WEST SUSSEX COUNTY COUNCIL CONSULTATION

TO:	Arun District Council FAO:David Easton
FROM:	WSCC - Highways Authority
DATE:	1 April 2022
LOCATION:	Land North of Hook Lane Pagham PO21 3PD
SUBJECT:	P/42/22/DOC Approval of details reserved by condition imposed under P/30/19/OUT relating to conditions 5-schedule of materials and finishes, 10-surface water drainage, 11-discharge flows to watercourses, 12-maintenance and management of surface water drainage system, 14-foul drainage system, 15-external lighting, 16-Construction Management Plan, 22-existing vehicular access onto Sefter Road and Pagham Road have been physically closed, 23-plans and details and timetable for installation of dwellings, 24-pedestrian and cyclist access points, 27-Broadband provision, 29-enhancement of existing hedgerows for use by bats and 33-Electric Vehicle Charging Strategy.
DATE OF SITE VISIT:	n/a
RECOMMENDATION:	Advice
S106 CONTRIBUTION TOTAL:	n/a

Project **Hook Lane, Pagham**
Drawing **Site Layout - Construction Management Plan**

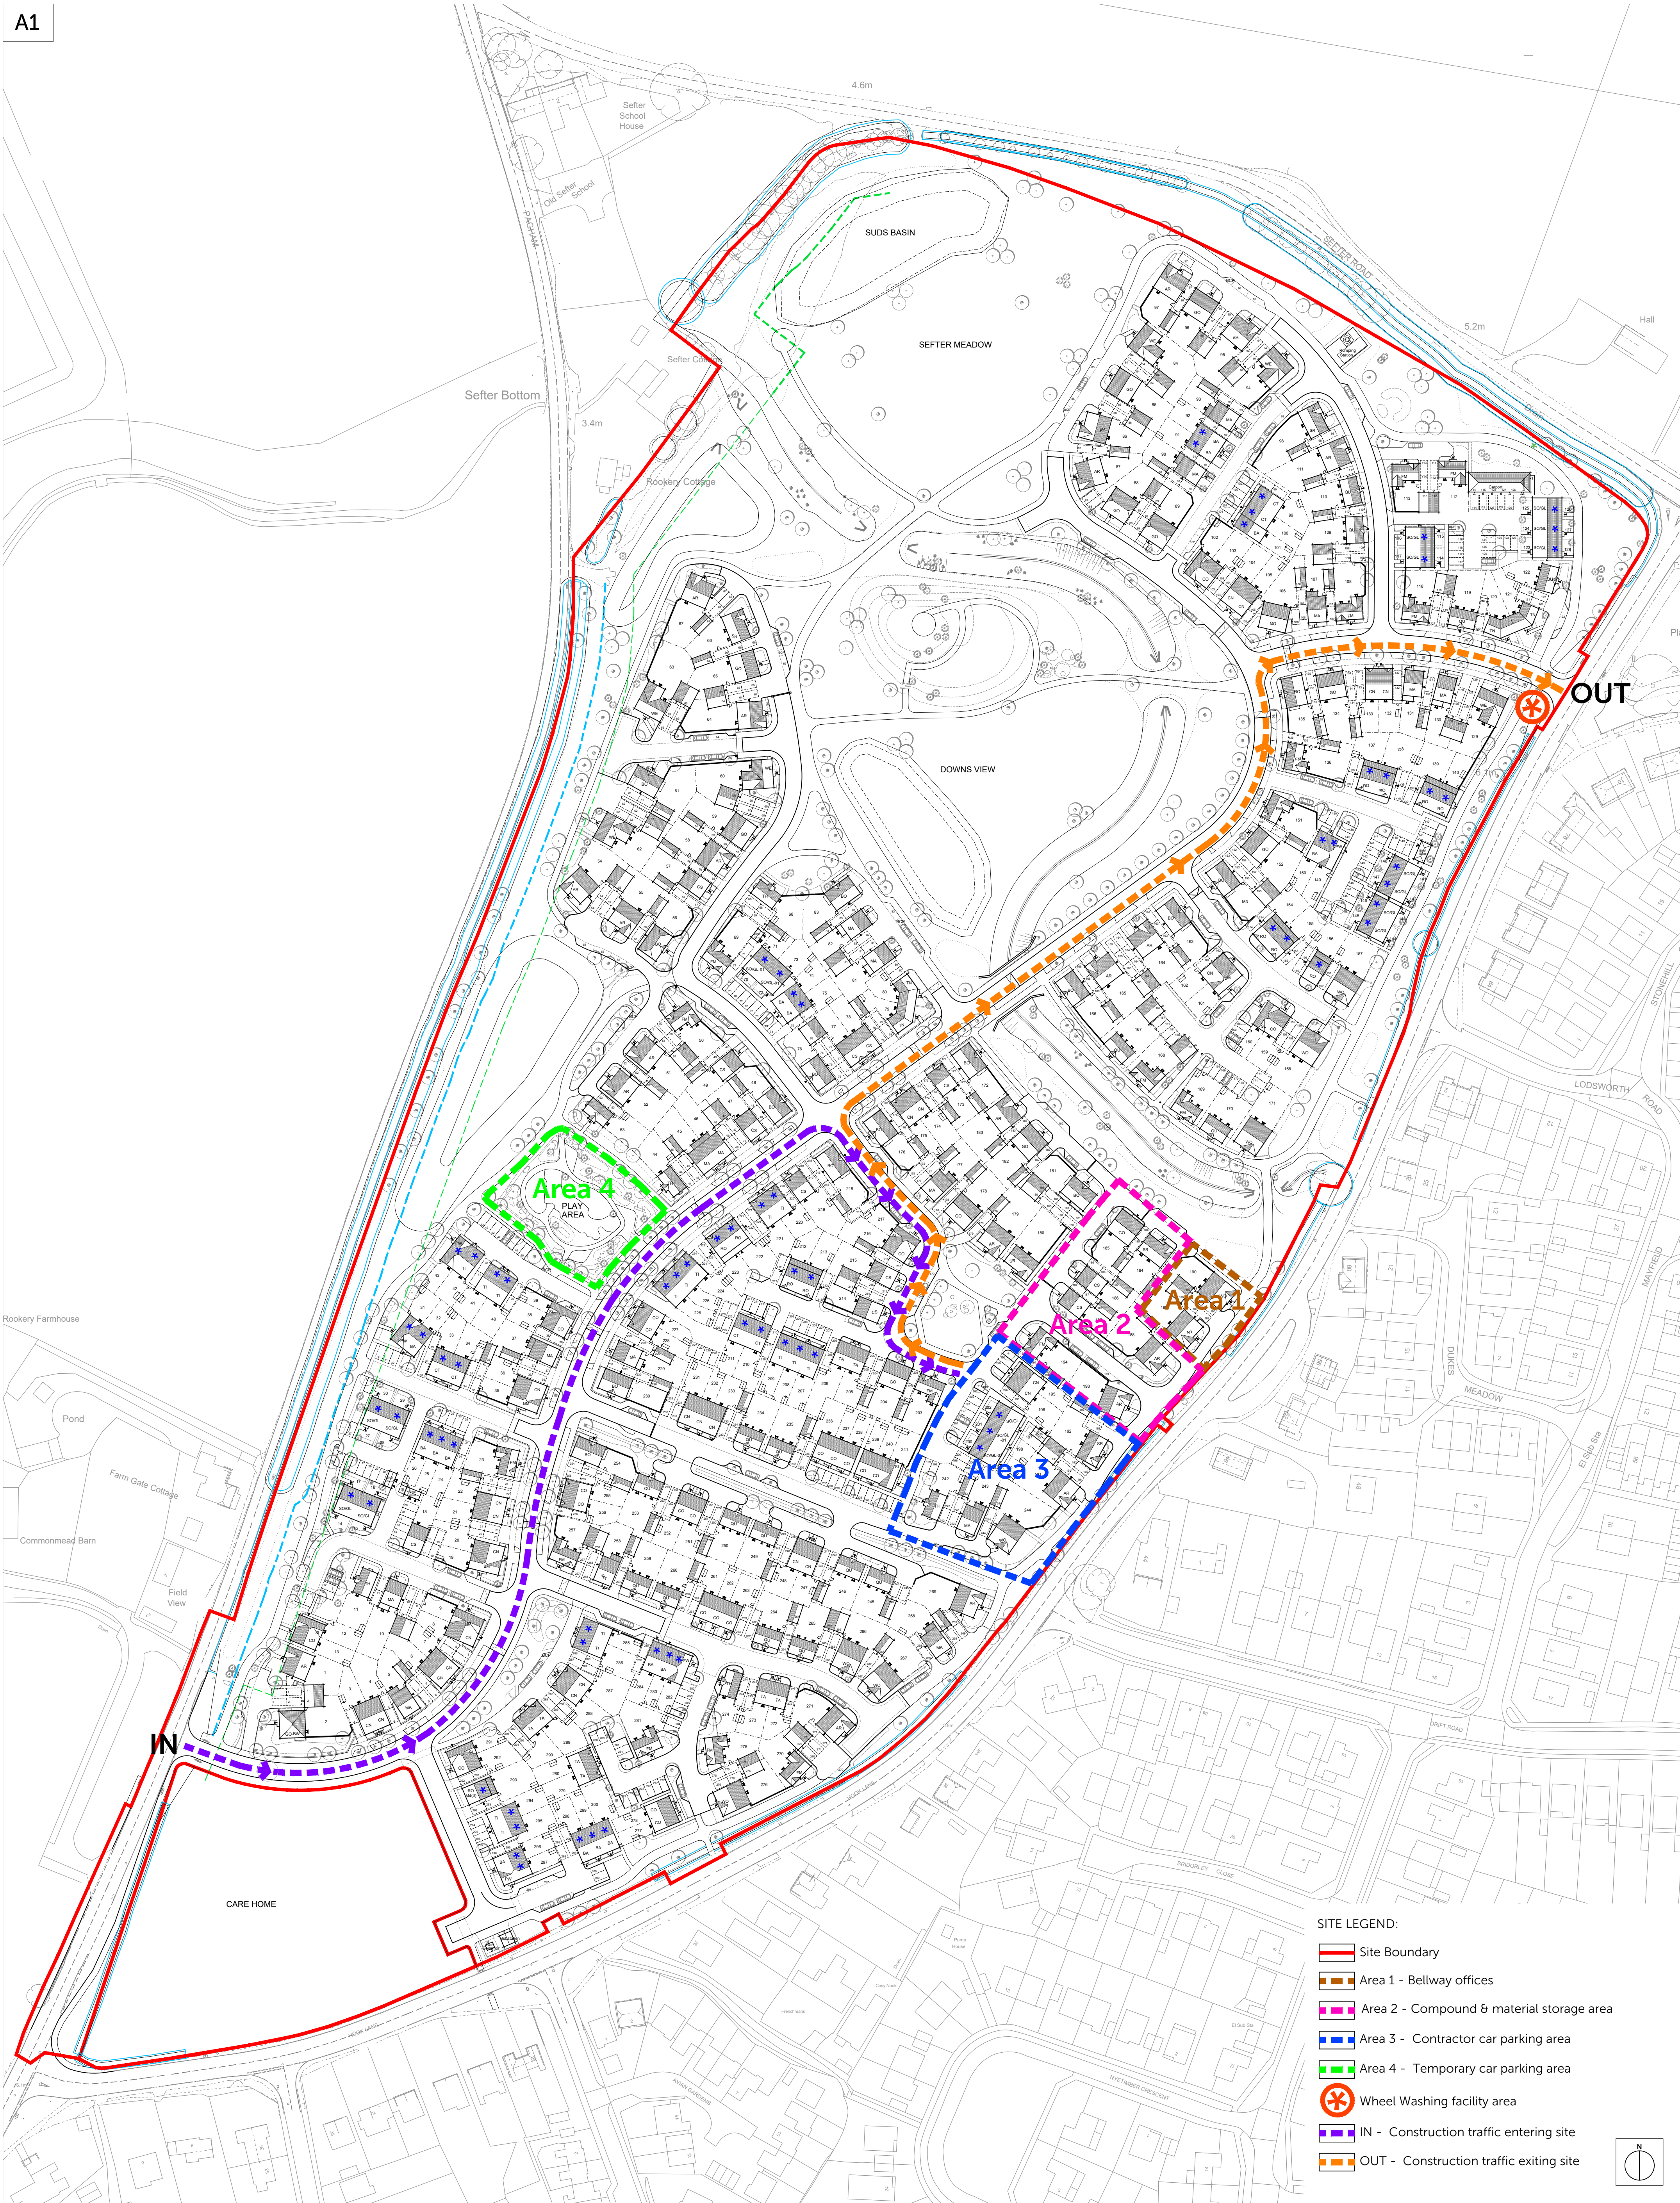
16 (Construction Management Plan) – The only comment would be the lack of details in terms of proposed routing to the site from the wider highway network. This should be clarified.

It's accepted that some deliveries may need to arrive from the east. This should not be the predominant direction for construction traffic to arrive from or depart to however.
